Together Against Sizewell C

SIZEWELL C PLANNING APPLICATION INQUIRY (IP no. 20026424)

DEADLINE 8: ORAL REPRESENTATIONS & COMMENTS REGARDING ISH10 ECOLOGY

24 September 2021

Figure 1.1: Locations of Unit 1 cooling water intake head position options (two to be installed) at the offshore Coralline Crag.

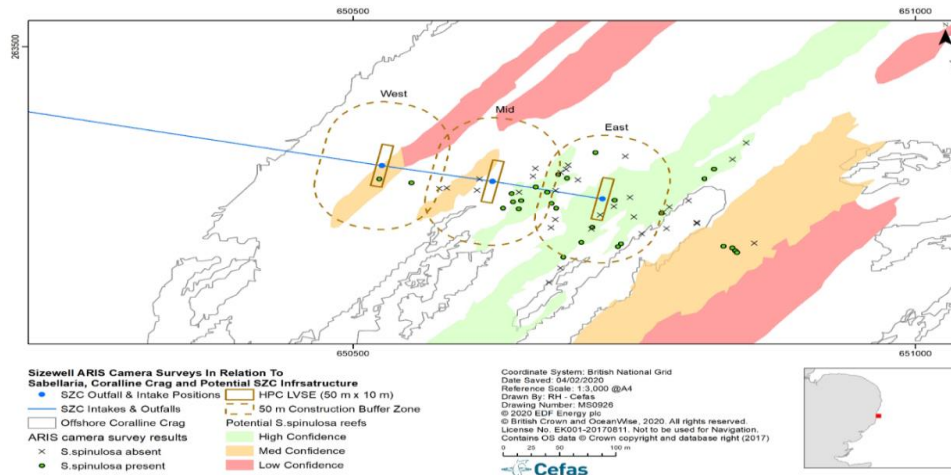
TASC were concerned to learn that *Sabellaria spinulosa* (SS) is present at the locations the Applicant is choosing to locate the heads for its cooling water intake tunnels. Surely as a protected species, any damage likely to occur to it needs to be avoided.

In discussion, the Applicant indicated that the 'least-worse' location in terms to causing harm to SS would be chosen. Chris Wilson, on behalf of TASC, said that TASC felt that there needed to be an assessment by the Applicant setting out the comparative impacts on SS from the alternative locations for the intake heads.

Pete Wilkinson made the following oral contribution on behalf of TASC: "I wonder if the applicant can tell us what level of impact on the species is permitted. If they are protected, I assume that no level of impact is permitted. So, I think we need to know what level is permitted or what's their understanding of the permitted level of impact. And I think, going along with what Chris Wilson said, we need to know what level of impact is associated with each intake tunnel, that will be very useful information."
